Alterations and extension to conservatory, first floor side extension, balcony area at first floor, alteration of windows on rear first floor to create Juliet balconies, balcony doors & new window on ground floor side elevation.

Anchors Cast 2 Fosters Close Rustington

Thank you for your internet representation made on 24th July 2019 which has been recorded as '**an objection**' with the comments as follows:

Drawing Title:
Proposal Plans 15

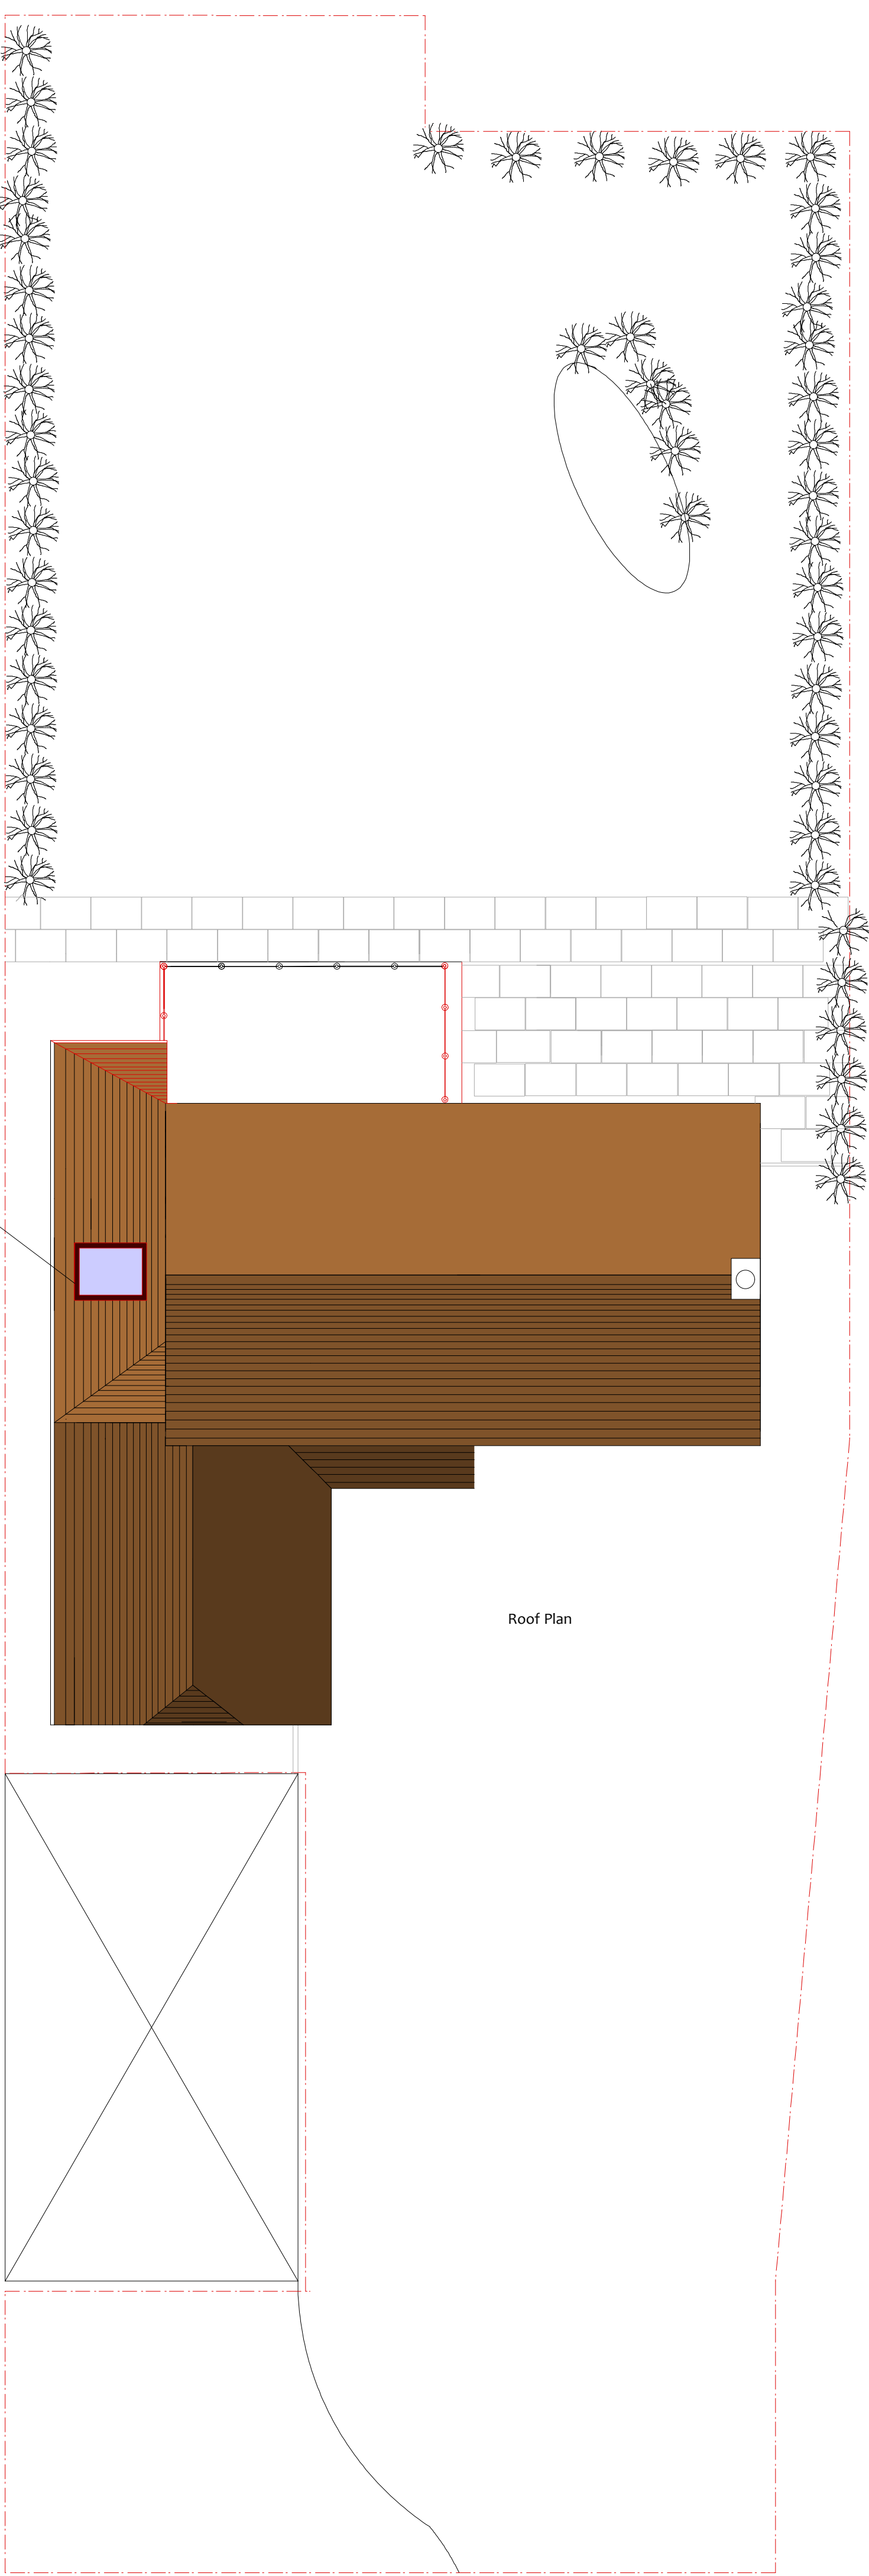
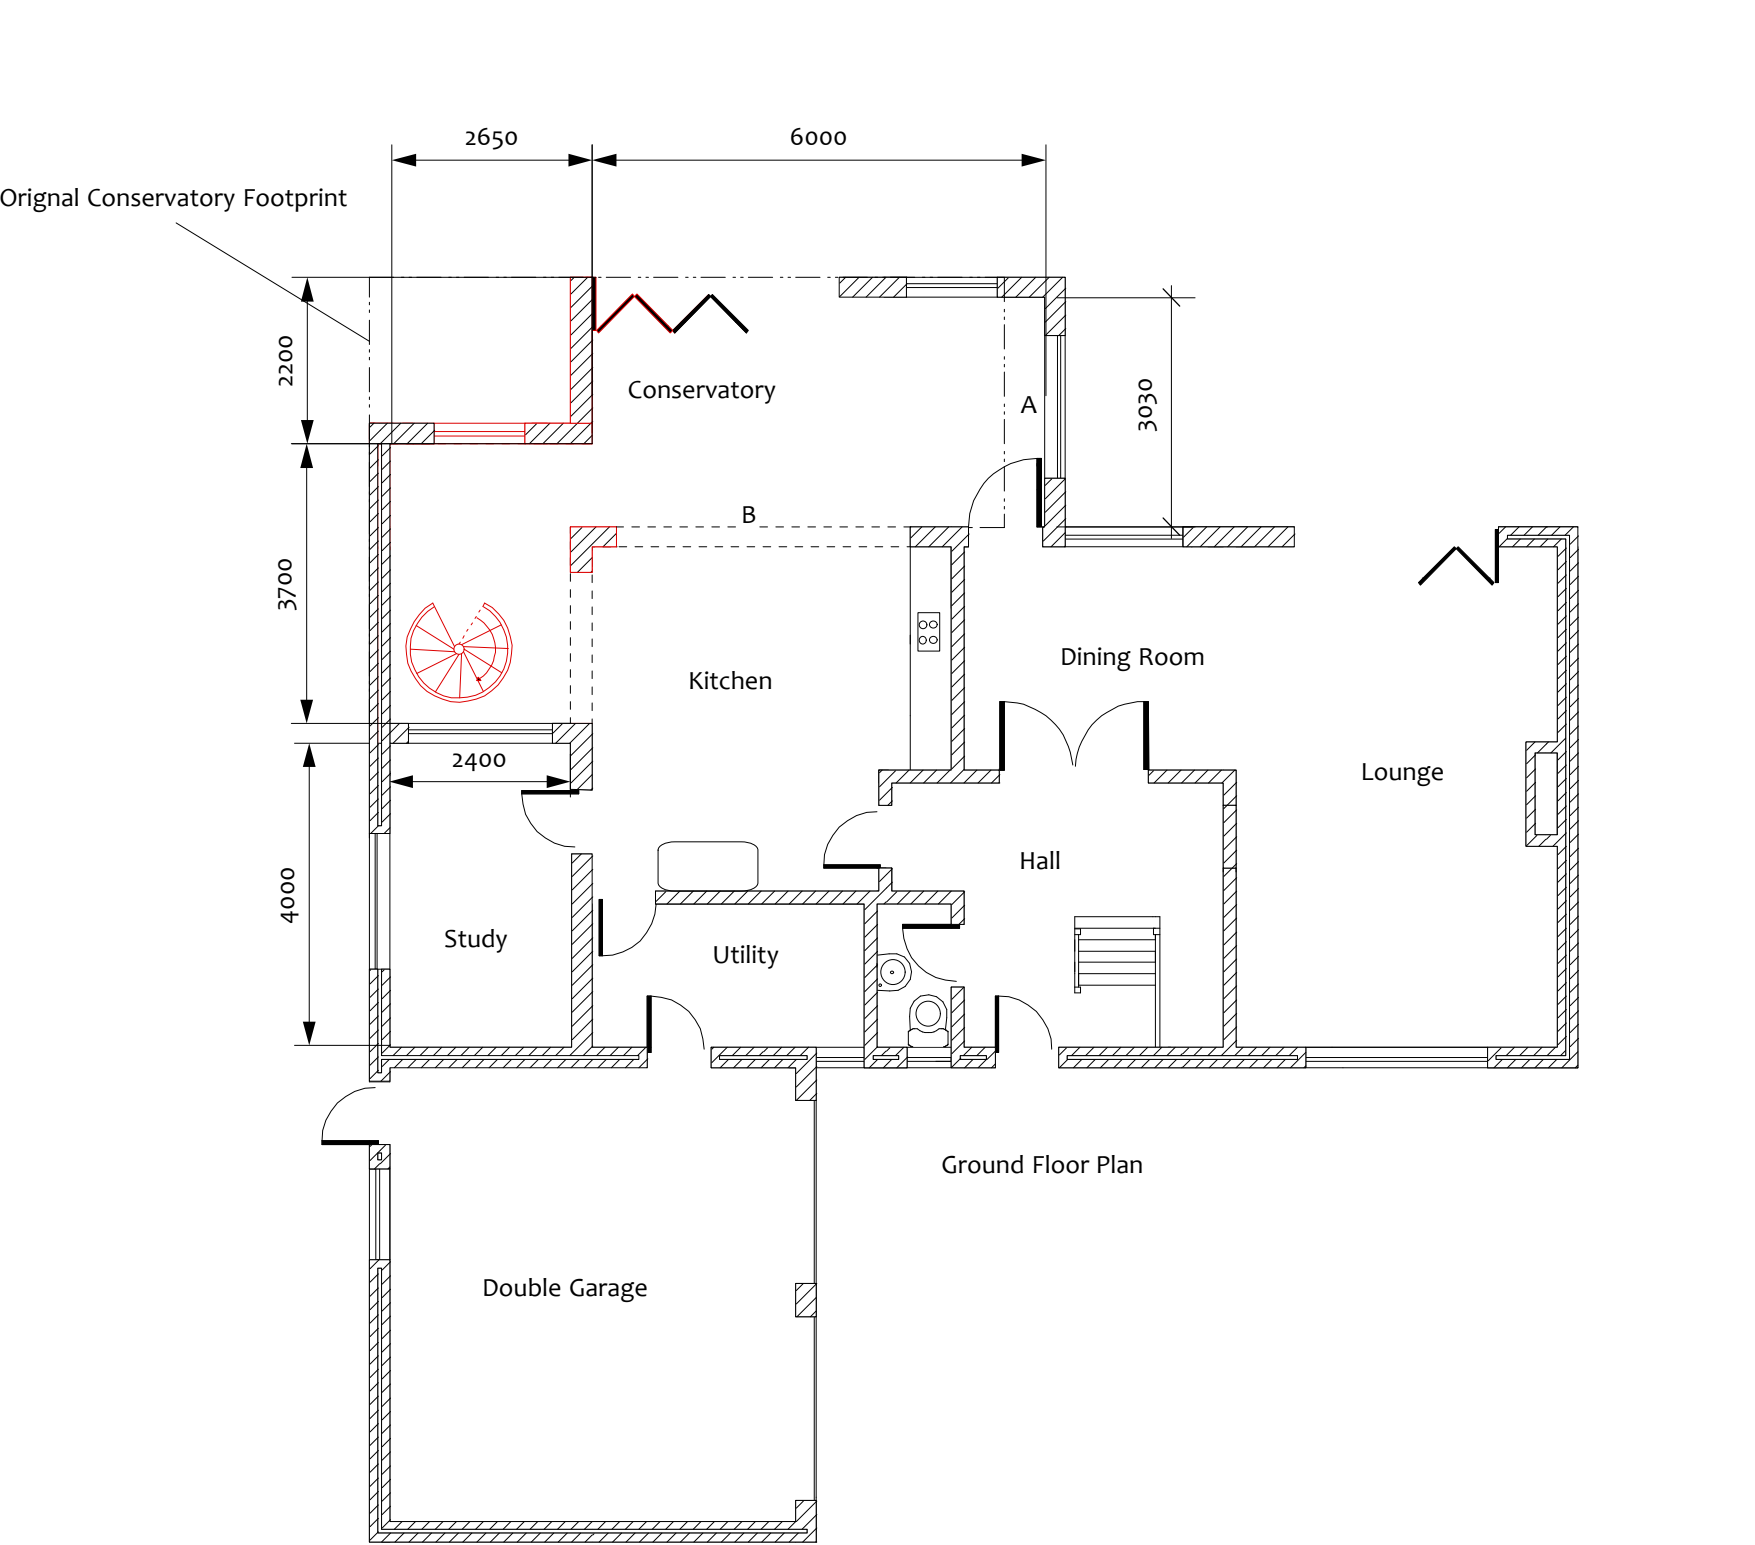
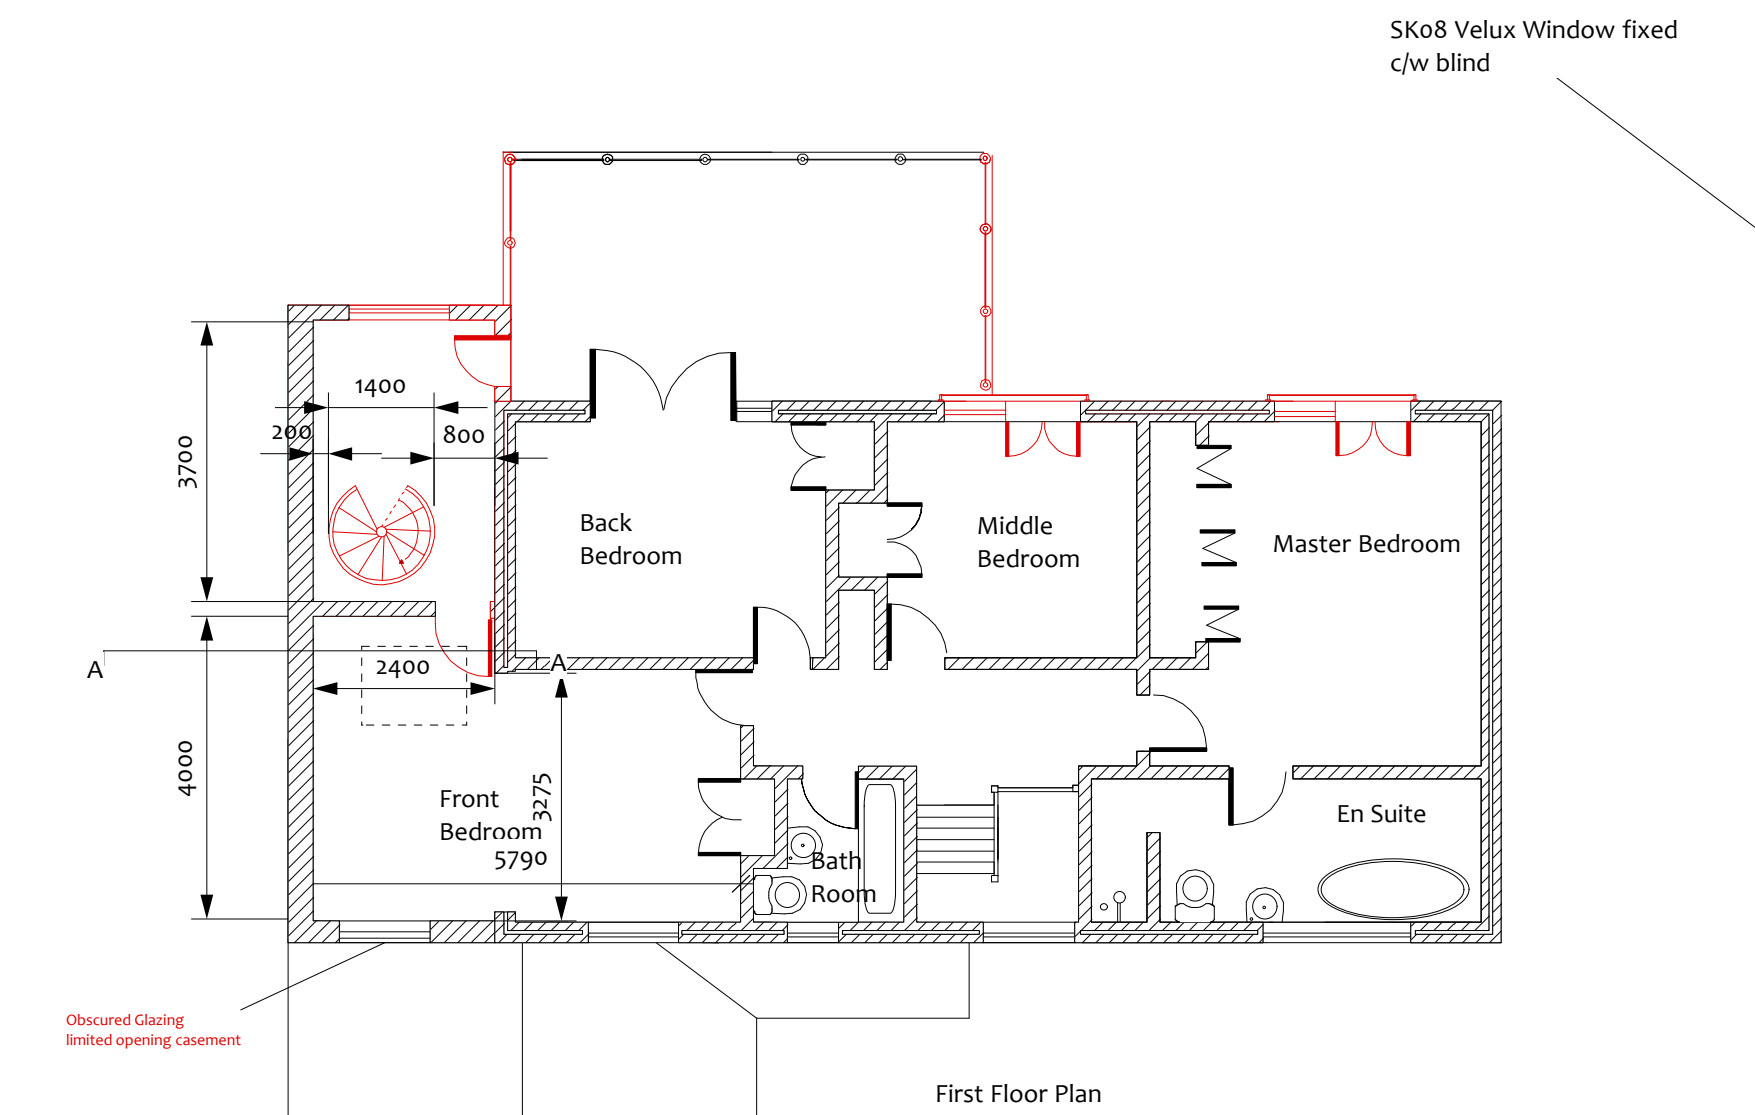
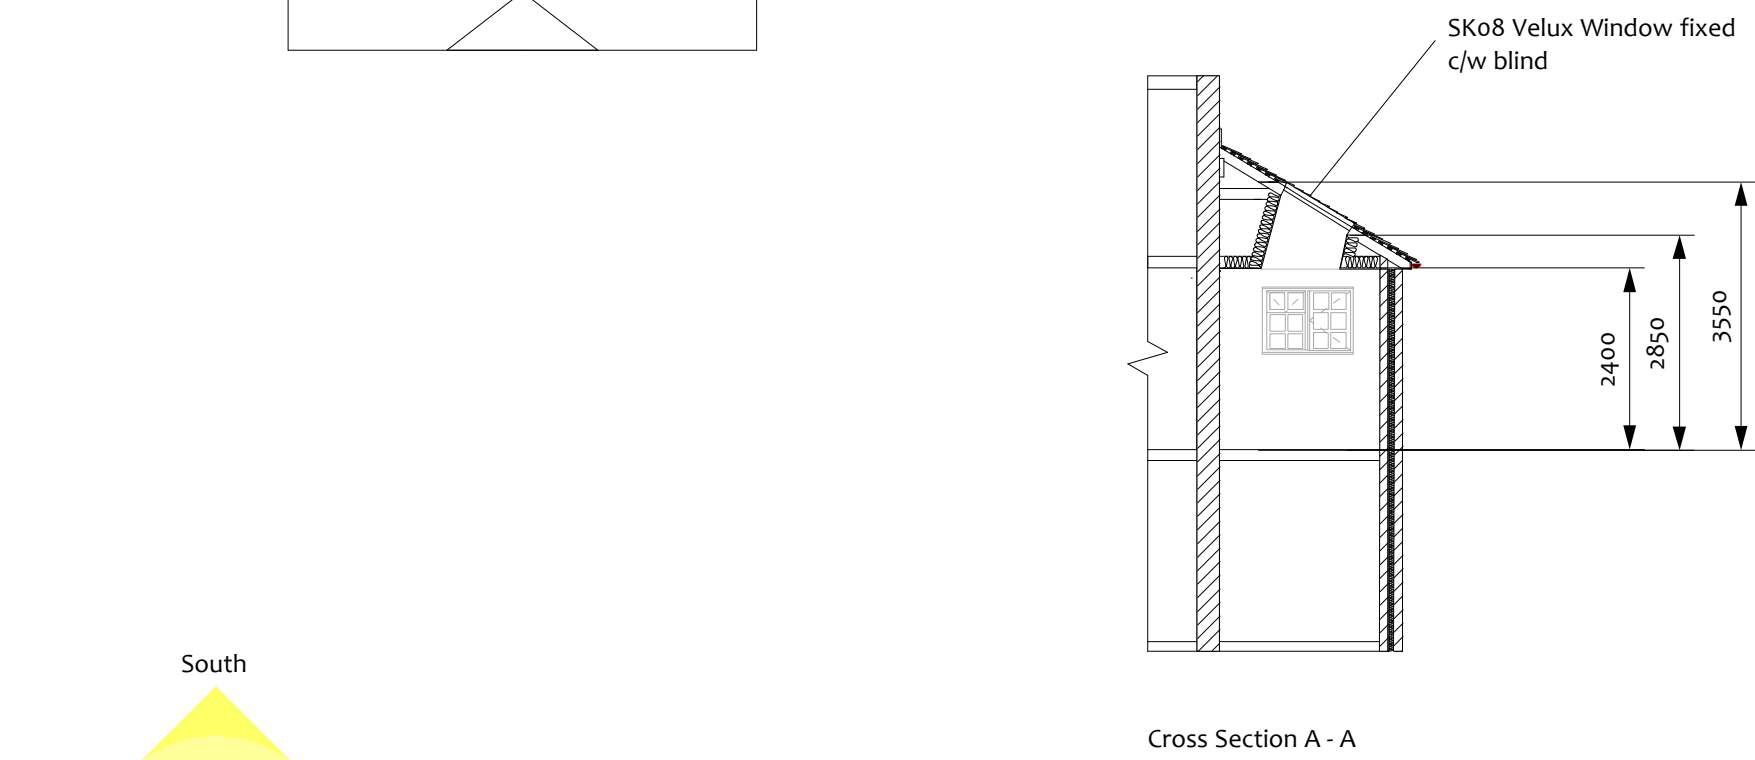
The Directors of Fosters Management Ltd, who own the Freehold of the block of 10 leasehold flats to the east of 2 Fosters Close, still object to the revised plans for this application, being drawing title "proposal plans 15" and number "IA/E/DJL/0408". Their objection is that, although the proposed extension of the reading room has been reduced from the original plans, it still extends out south beyond the existing building line which does not meet with the approval of Fosters Management Ltd.
